## ZAYO GROUP COLORADO SPRINGS, CO

RE: Zayo Group  
18370 Highway 94  
Colorado Springs, CO 80930

### REQUEST

Five Nine Design Group is the representing agent for Zayo Group in this submission for Planning Approval. For an addition of a fiber-optic utility shelter located in at an existing fiber-optic facility located in El Paso County. The shelter will be 420 SF and is unoccupied. The building will be constructed of pre-cast concrete and house fiber-optic telecommunications utility equipment.

OVERALL SITE PLAN

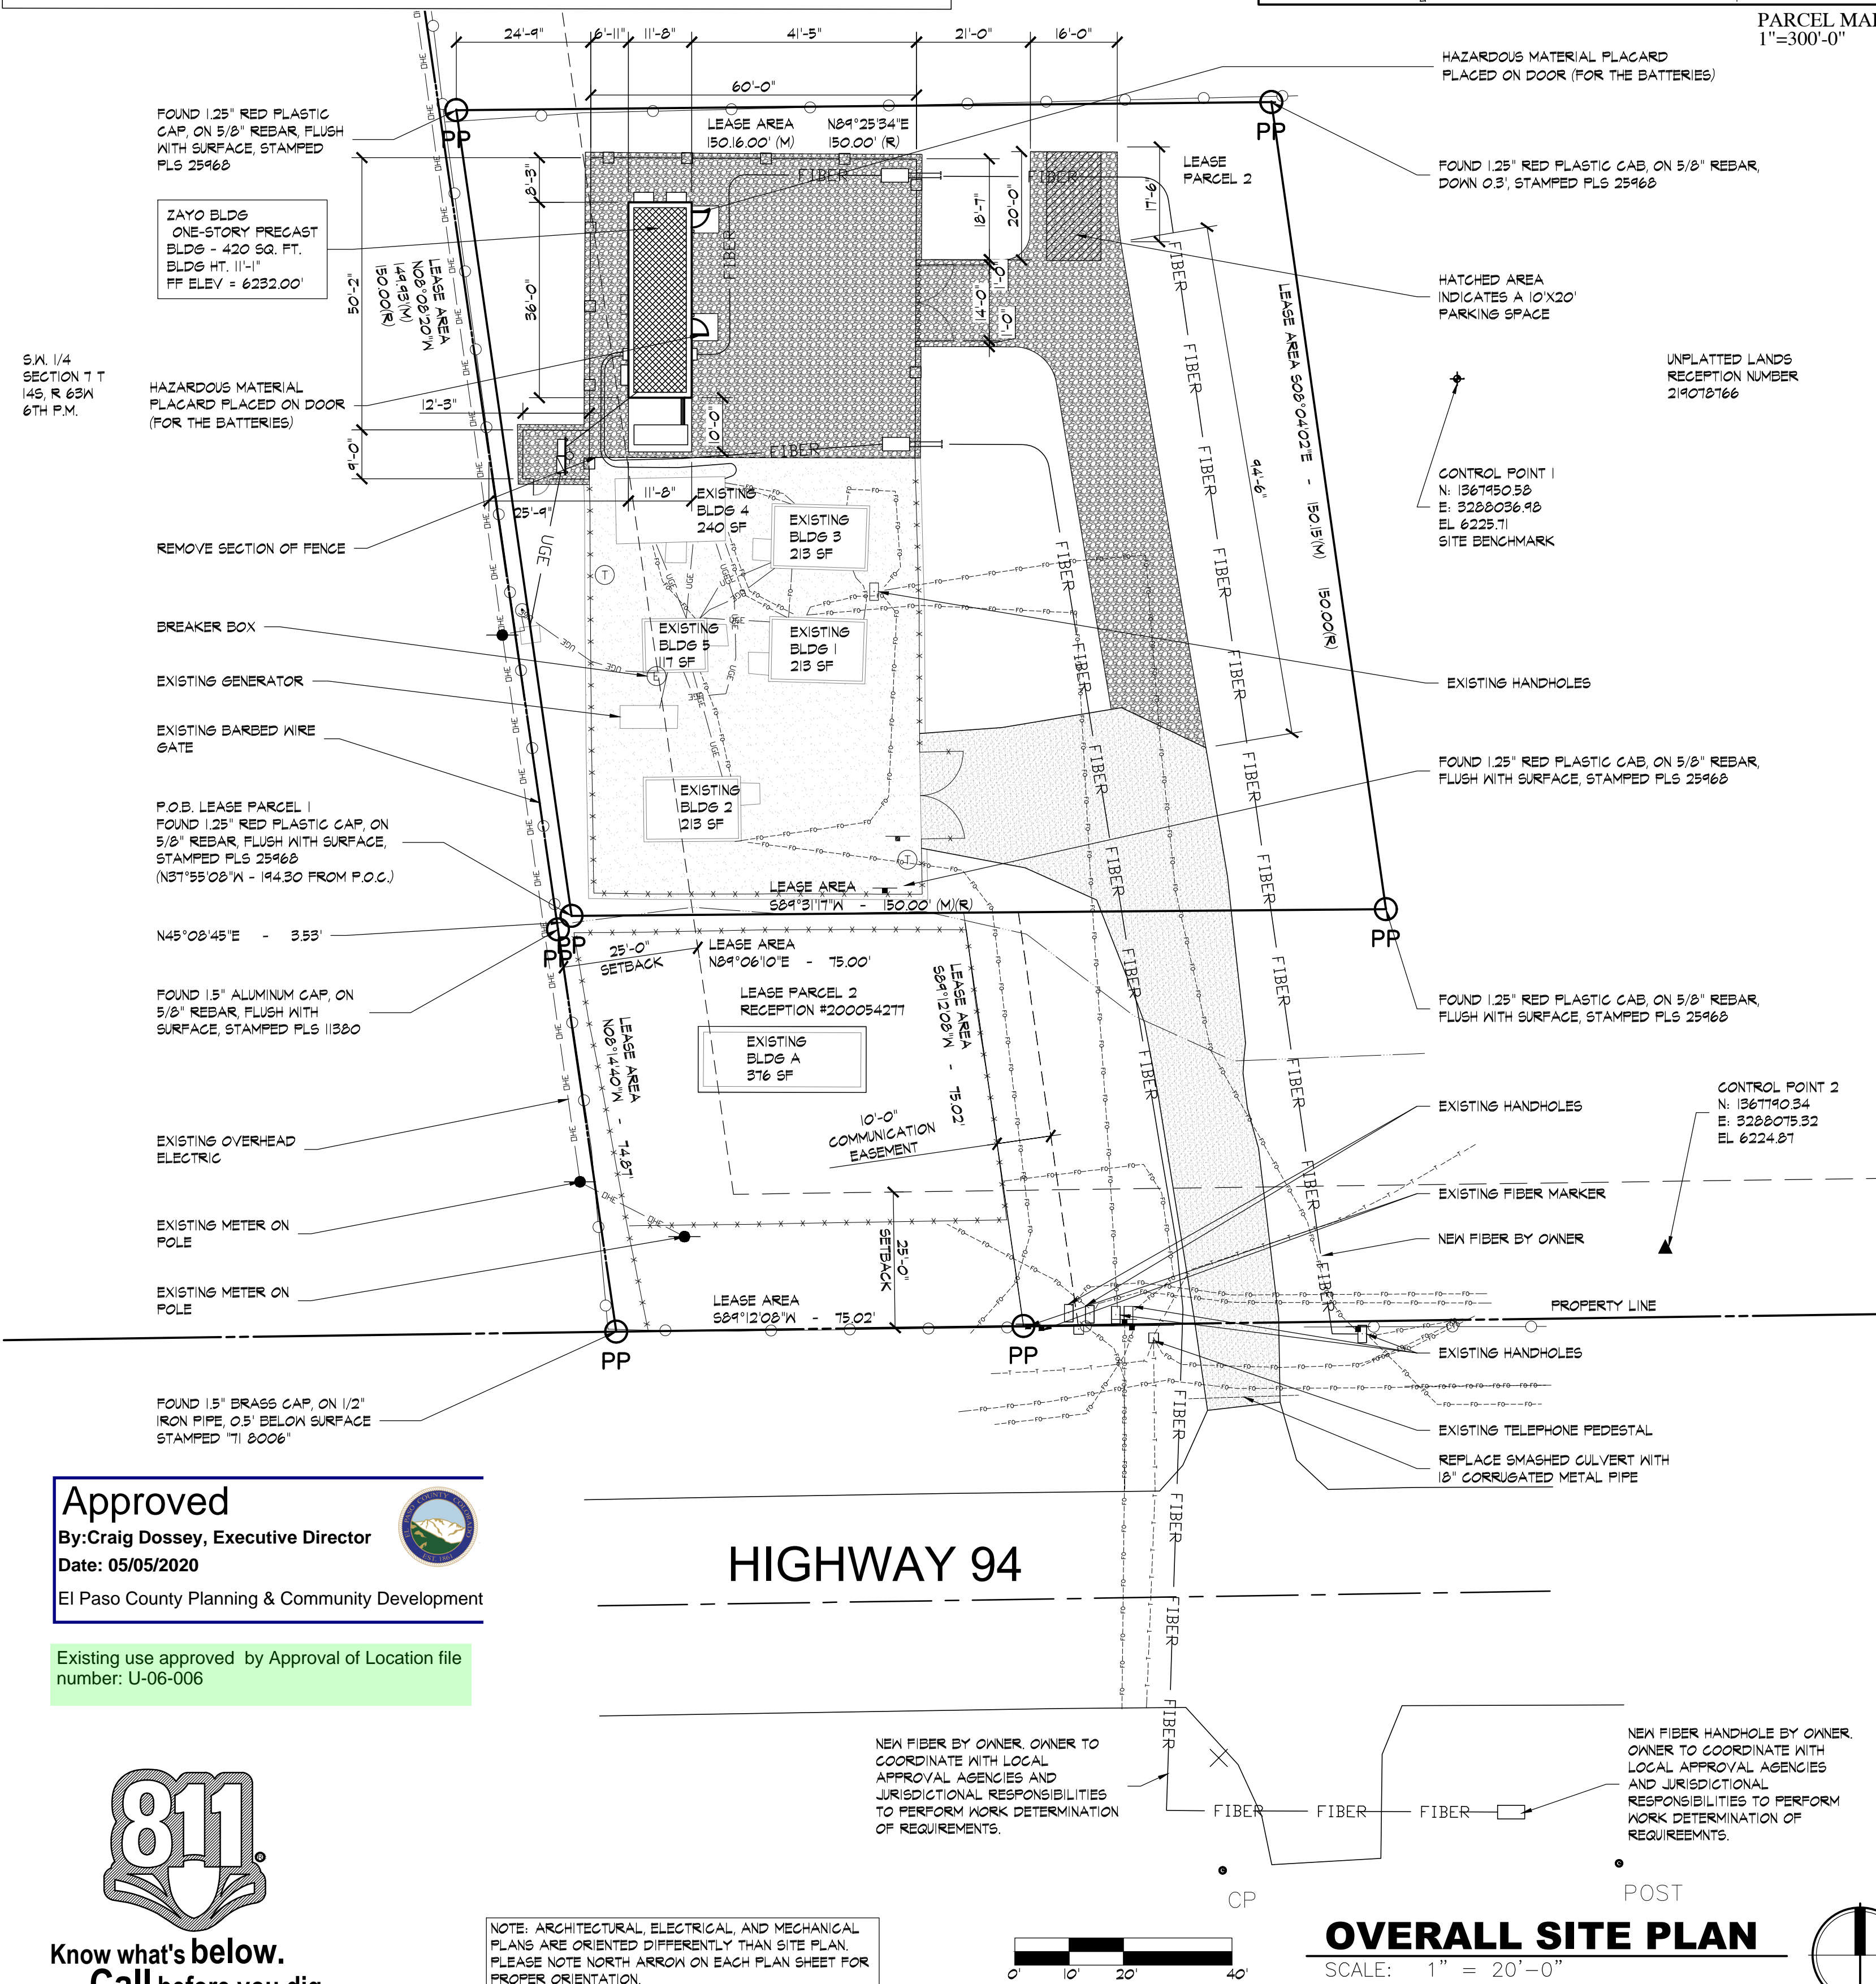
Review 1 comment: Per the site plan, the access is off of HWY 94. Please revise.

Review 2 comment: Revise.  
Unresolved

SHEET TITLE:
**ENLARGED SITE PLAN
AND DETAILS**

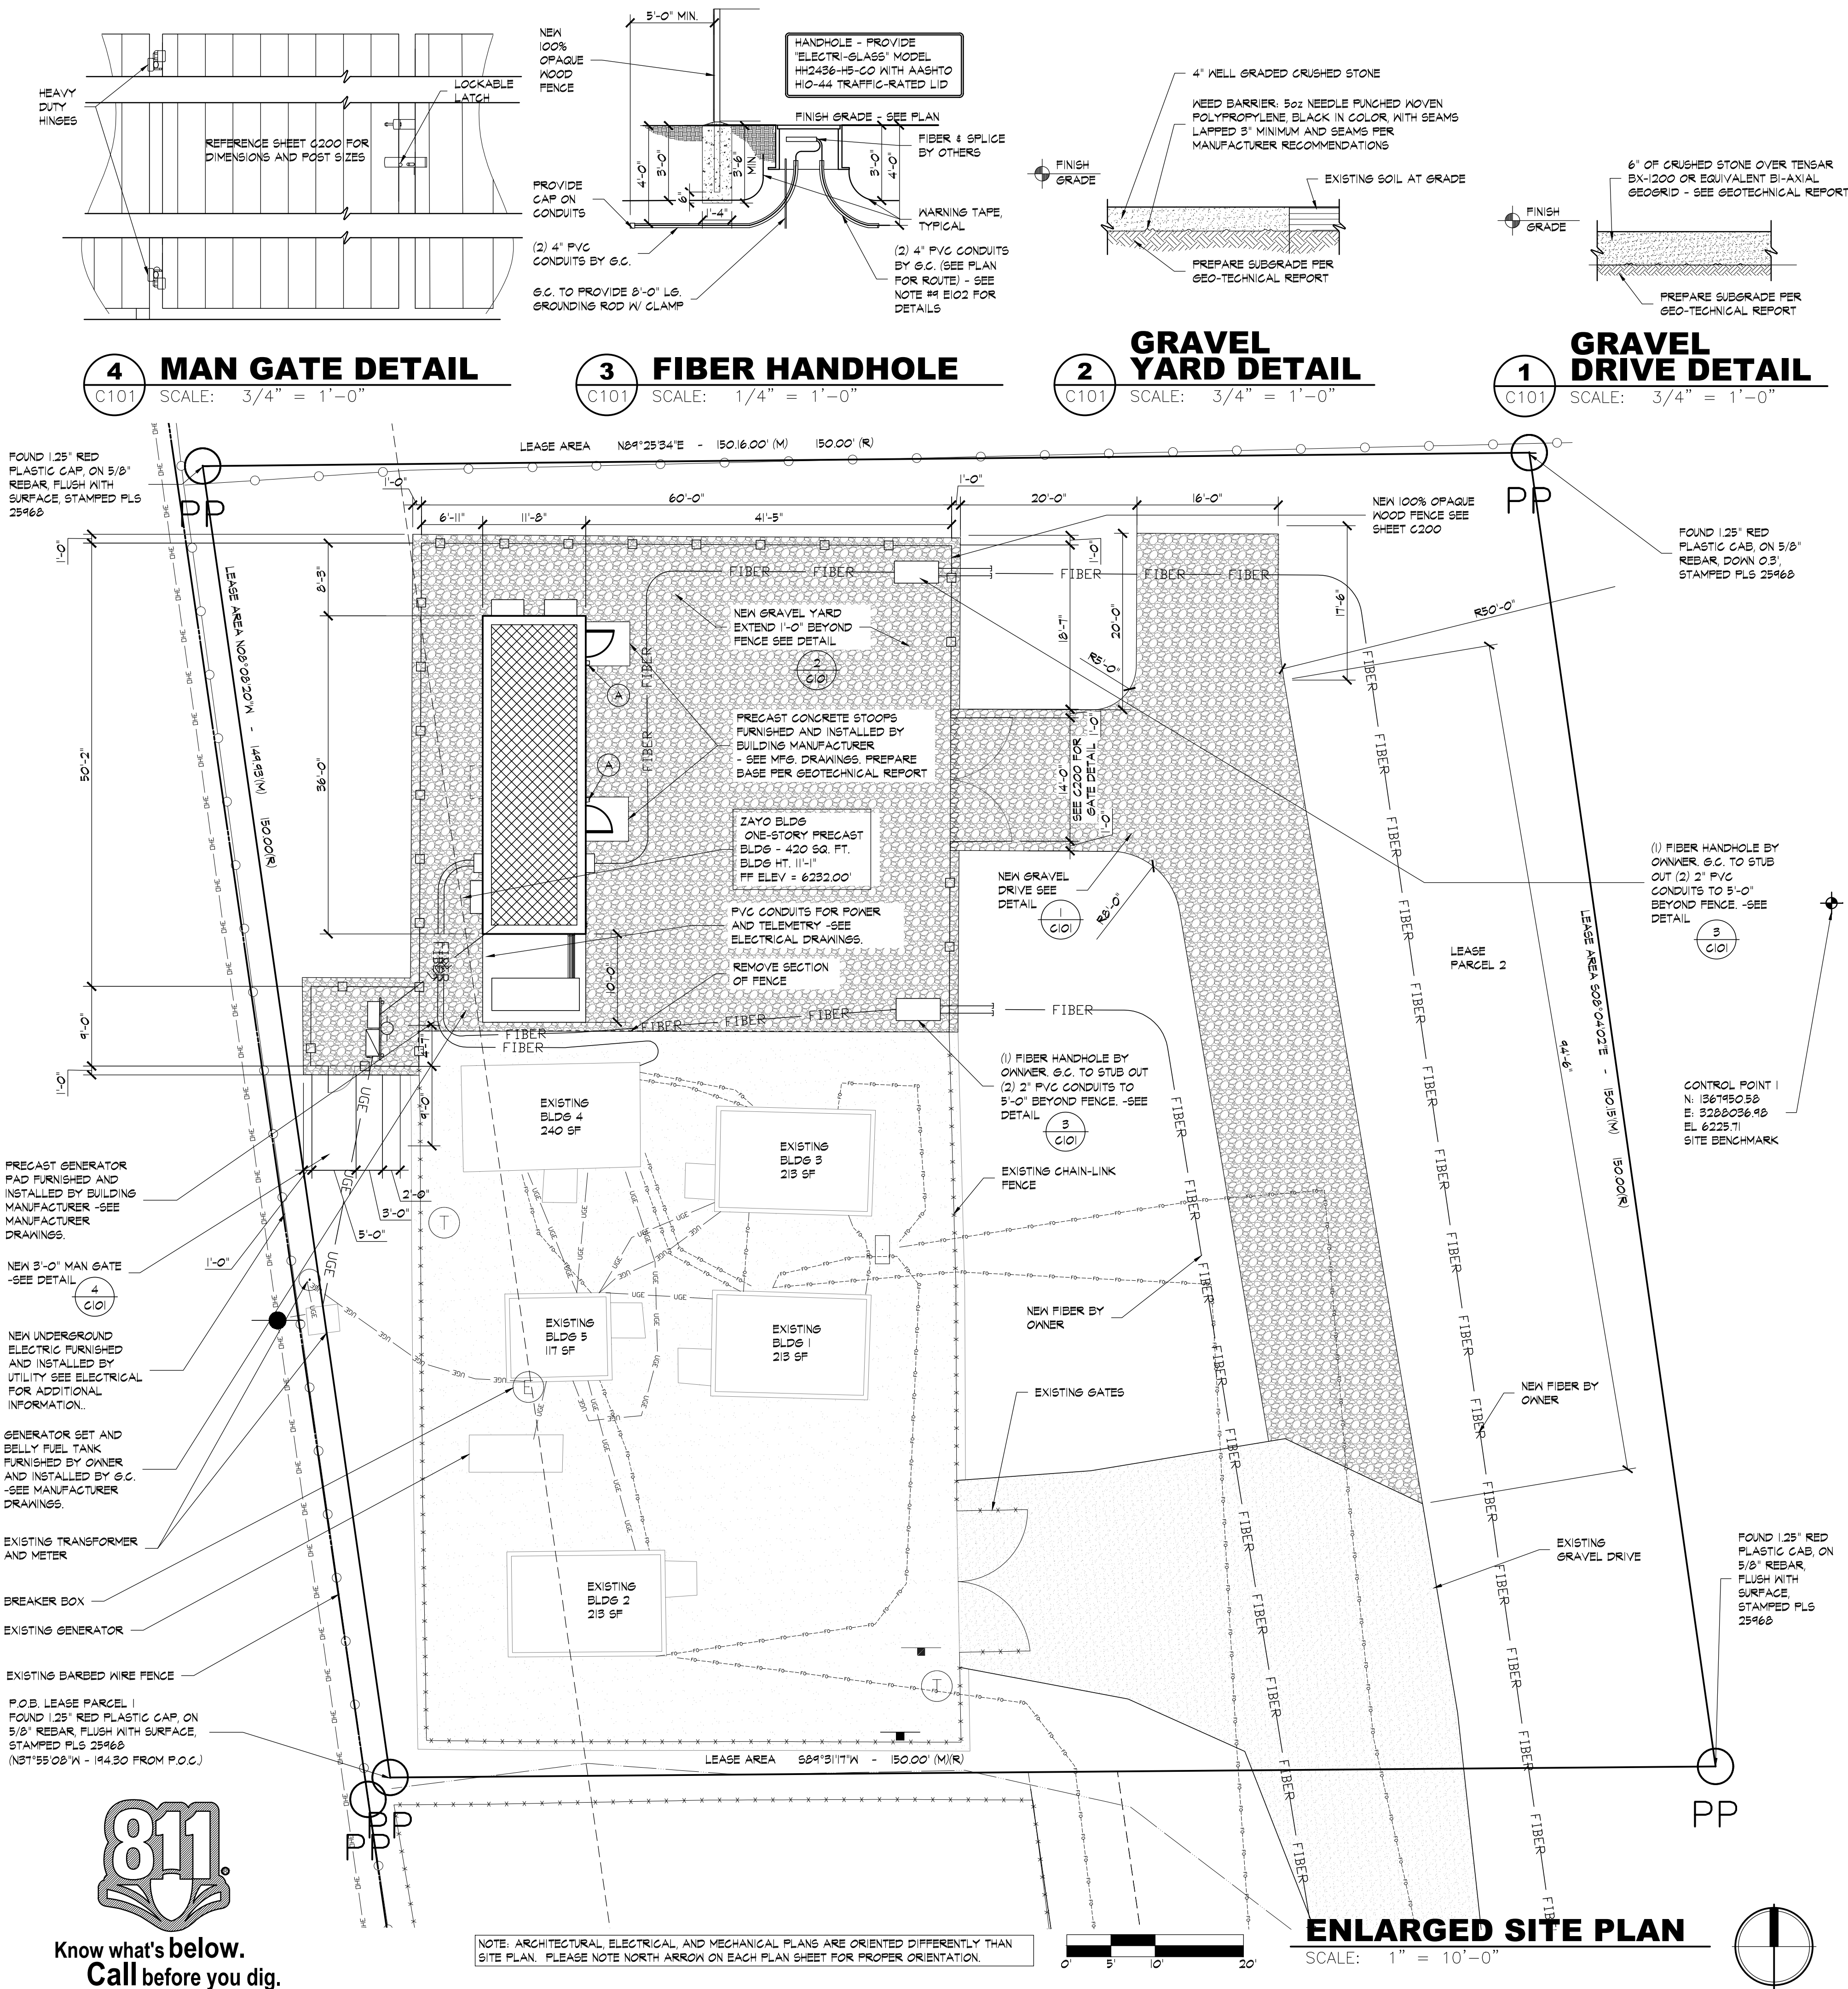
Review 1 comment: Please indicate the total area of land disturbance for the proposed site. Note that changing the surface material of the access drive is considered land disturbance.  
Review 2 comment: Revise accordingly.  
Unresolved.
